DECISION DELEGATED TO HEAD OF PLANNING

Application No: H16-0080-24 **Applicant:** Mr M S & Mrs T E Denton

Proposal: Proposed Extensions and Alterations

Location: 30 Alexandra Road Spalding

Semi-circular Balcony Handrail

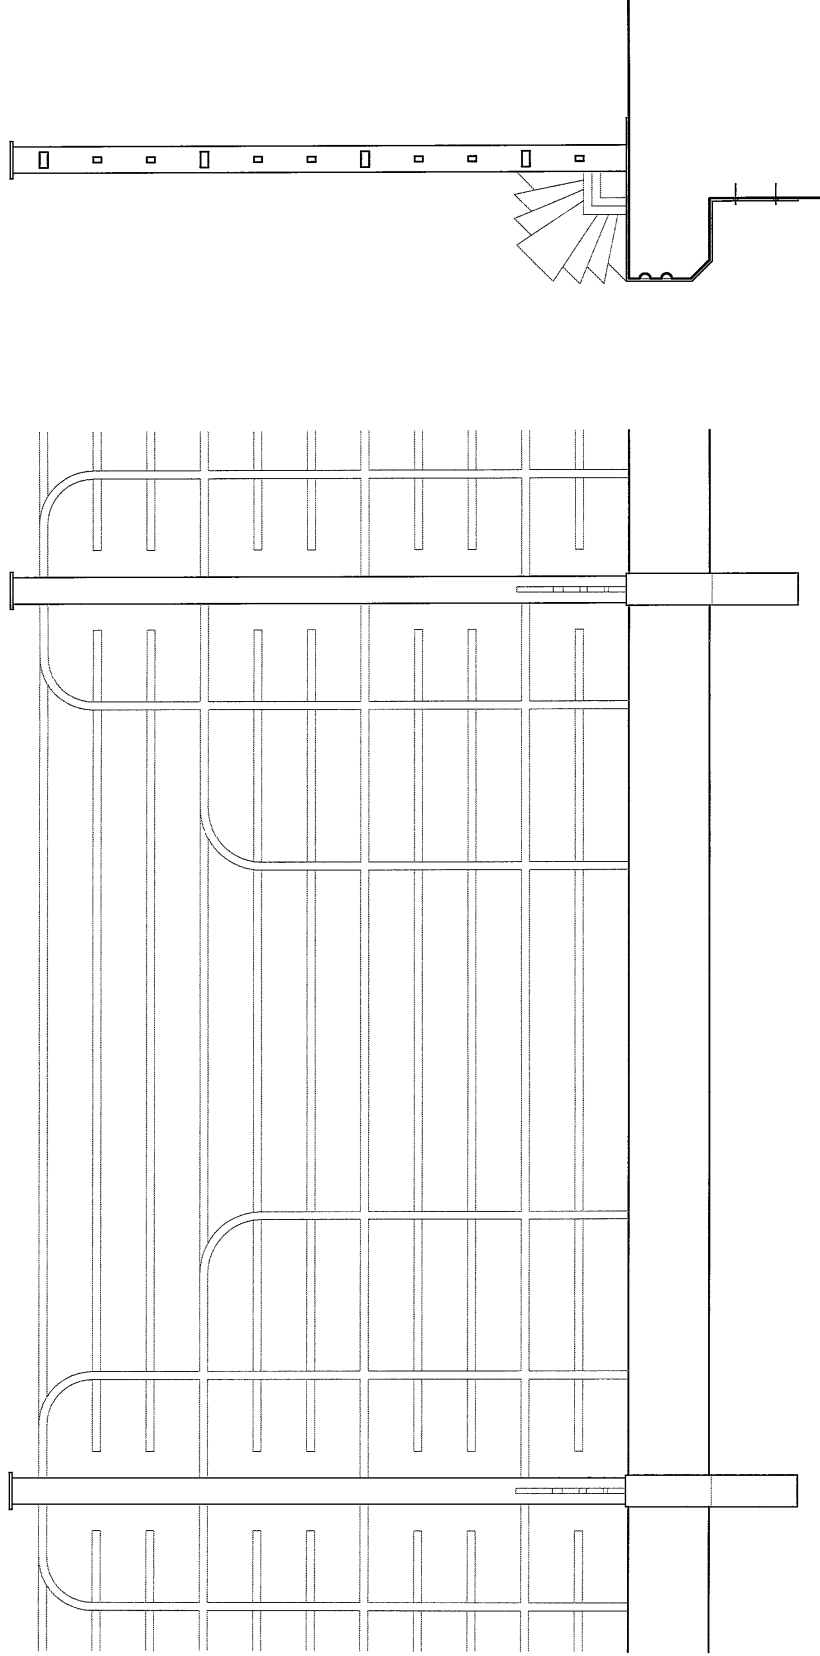
The proposed rear balcony would, due to its semi-circle shape, offer views into neighbouring dwellings. While the large hedging to the east would restrict views into 32 Alexandra Road to a certain extent, occupants would have unobscured views into the rear garden of 1 Lime Court. The potential for overlooking here is exacerbated by the proposed first-floor rear windows of the garage extension, which would look directly into the garden of 1 Lime Court. At the short distances present, the potential for overlooking is significant.

Proposed East & West Elevations

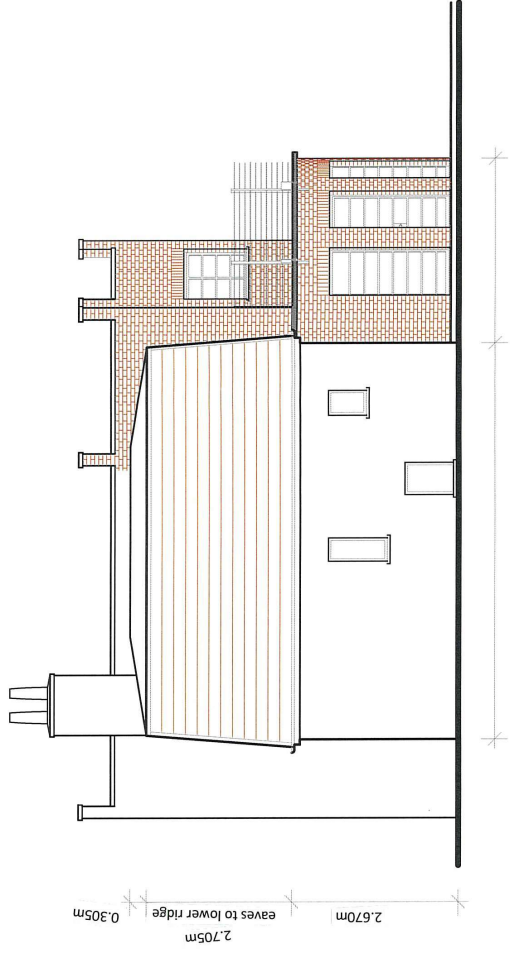
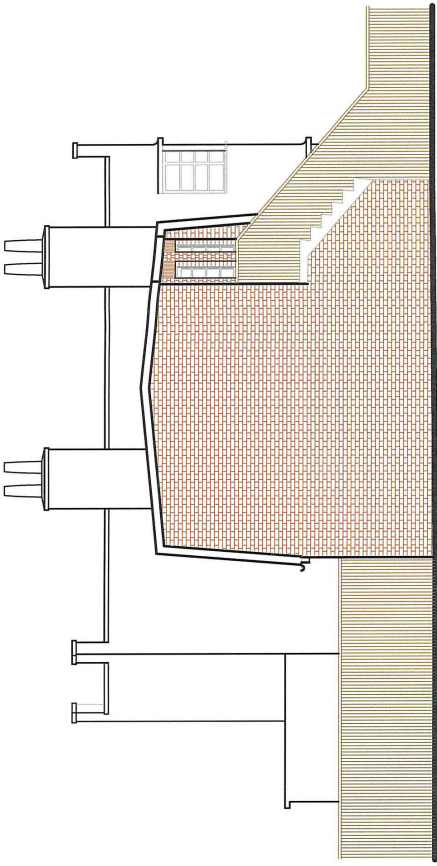
That being said, it is considered that the mansard roof is out of keeping with the character of the area. There is no common acknowledgement for mansard roofs, particularly of this scale, in the immediate area. As 30 Alexandra Road currently features flat roofs almost exclusively (with the exception of a mono-pitched rear conservatory), the addition of a pitched roof would clash with the host dwelling. While mansard roofs are suitable for art deco properties, they require clear integration with the host and additional design features such as parapets to incorporate them with the host; these are not present here. The above factors would combine to create an incongruous feature, out of keeping with the area and the host.

Paragraph 124e of the NPPF specifically concerns mansard roof extensions, stating that LPAs "should also allow mansard roof extensions on suitable properties where their external appearance harmonises with the original building". In this instance, it is considered that the extension would not harmonise with the original building, instead appearing discordant with the host. The explanatory text within the NPPF glossary goes on to state that mansard roofs are "generally regarded as a suitable type of roof extension for buildings which are part of a terrace of at least three buildings and at least two stories tall, with a parapet running the entire length of the front facade". 30 Alexandra Road does not entirely conform to this definition, and as such, it is considered that a mansard roof extension is inappropriate for the dwelling.

The garage extension would abut the boundary with 1 Lime Court. At a height of 5000mm with minimal separation distance, the proposal would significantly overshadow the front garden of the adjacent dwelling; detrimentally impacting upon the amenity of the occupants.

1250mm from 32 Alexandra Road. While no windows are present in the corresponding elevation of 32 Alexandra Road, the mansard roof would overshadow the rear garden of this neighbouring dwelling. The separation distance and boundary treatments are not significant enough to prevent the extension from casting a significant shadow over the adjacent property. This would be to the detriment of the amenity and wellbeing of the occupants of 32 Alexandra Road.
